Application number: 2025/90910	
What is the application for?:	Erection of 4 semi-detached dwellings
Address of the site or building:	Land Off, Caledonian Road, Savile Town, Dewsbury
Postcode:	WF12 9QJ

## User comments

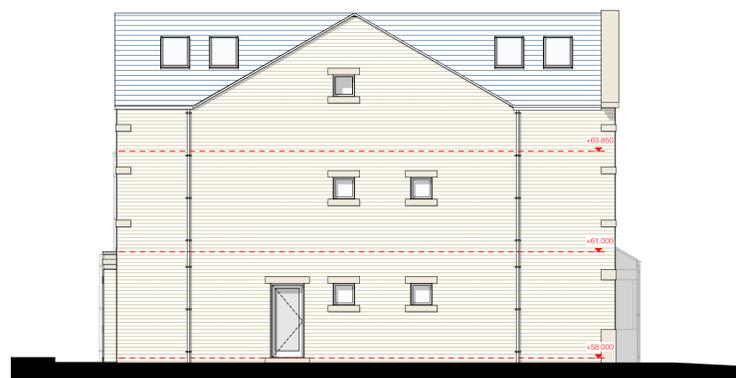
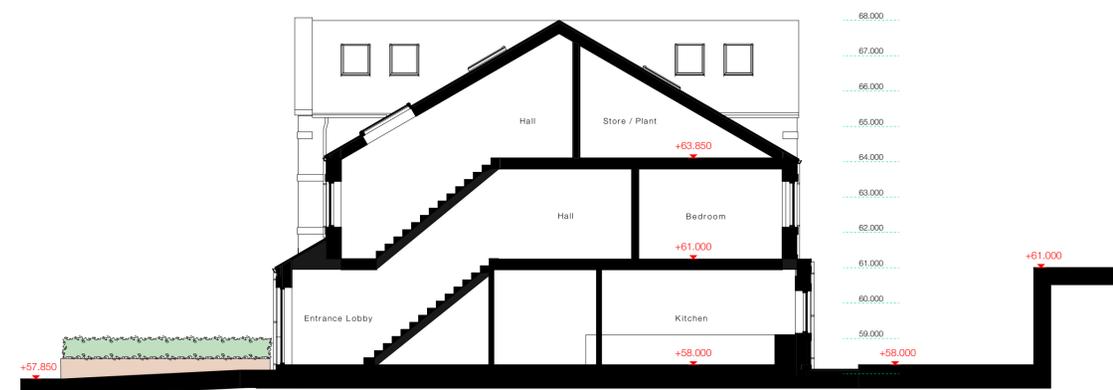
Type of comment: A general comment	
Do you wish your comments to be published on the website anonymously?	Yes
<p>Dwellings are 3 storey high. These will obstruct the view and the morning sunlight from east to my and my neighbour's property.</p> <p>A 2 storey dwellings are more suited in this area.</p> <p>The excavations for the retaining wall are unsupported at rear of proposed dwellings and retaining walls need to be completed by the developer before starting work on the dwellings.</p>
